# ENG-CDR21013-R2-GEO.pdf Markup Summary

WINGWALL N1 PROFILE

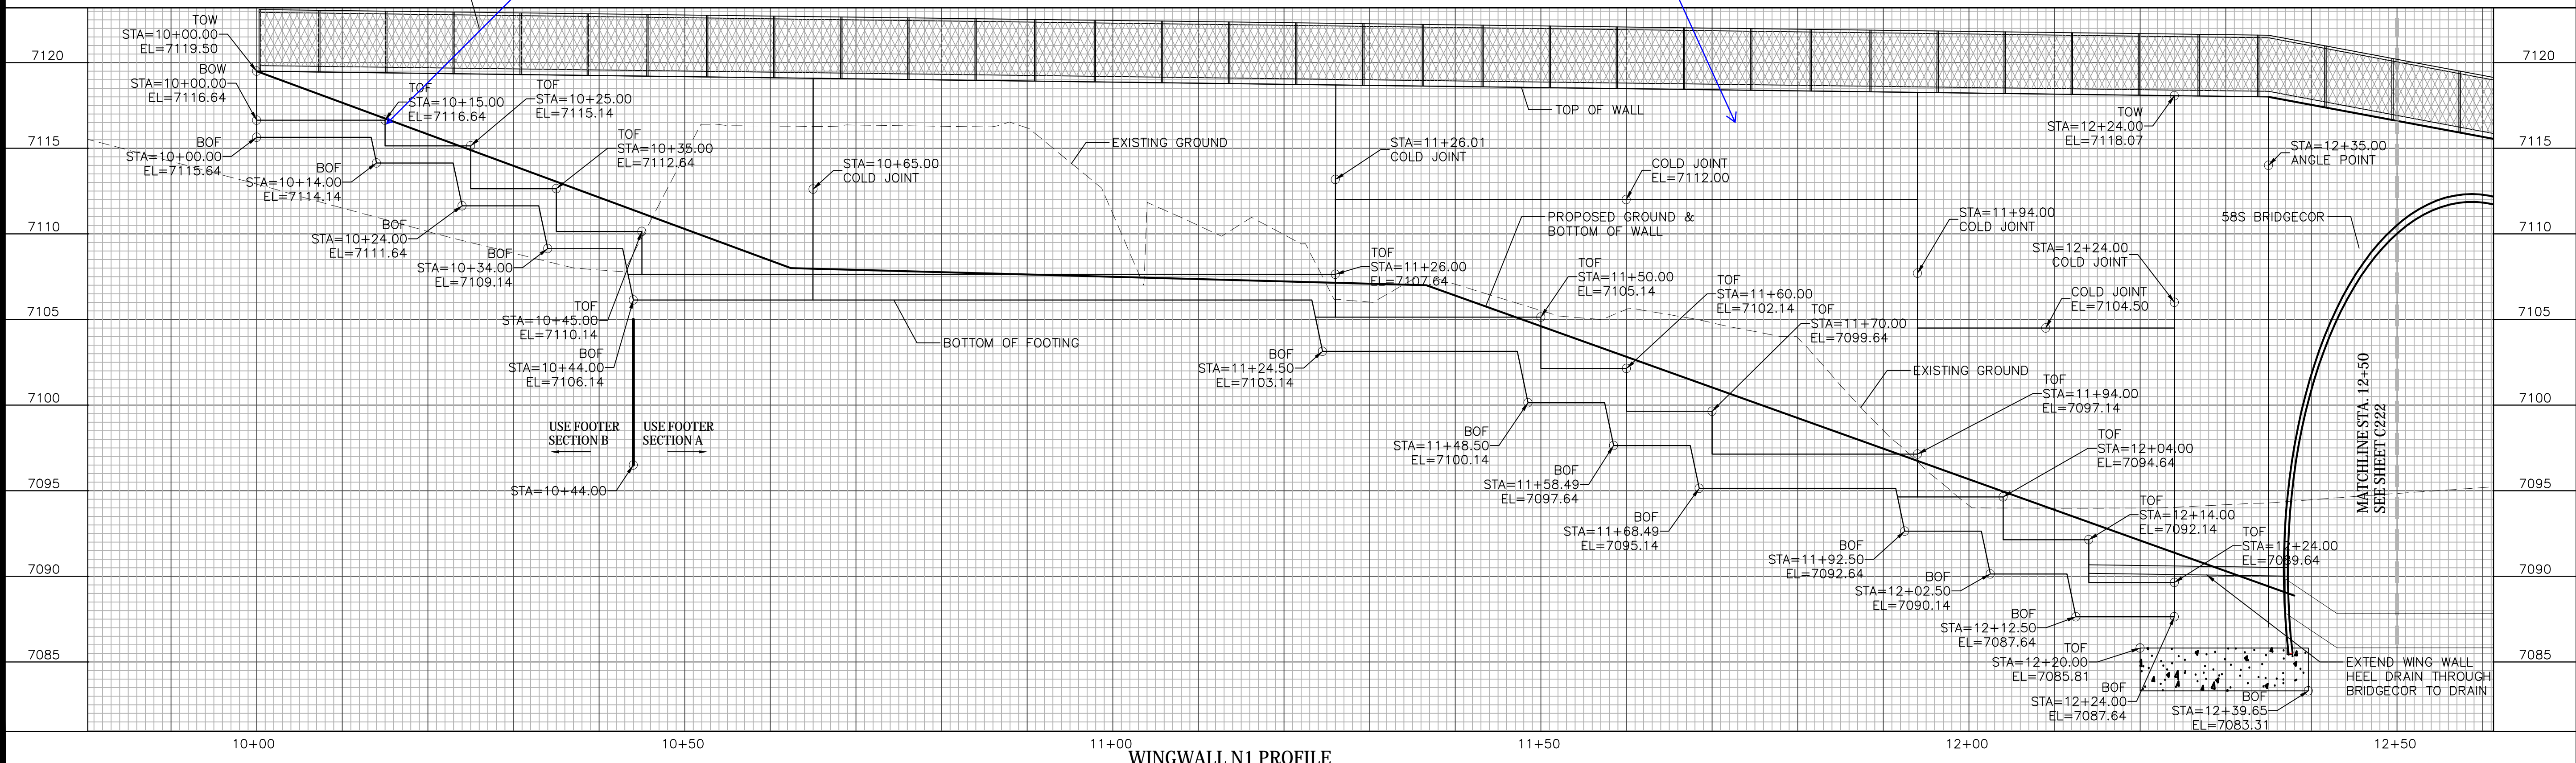
CDOT REQUIRES BASE OF FOOTING TO BE 36 INCHES BELOW FINISHED GRADE FOR FROST PROTECTION.
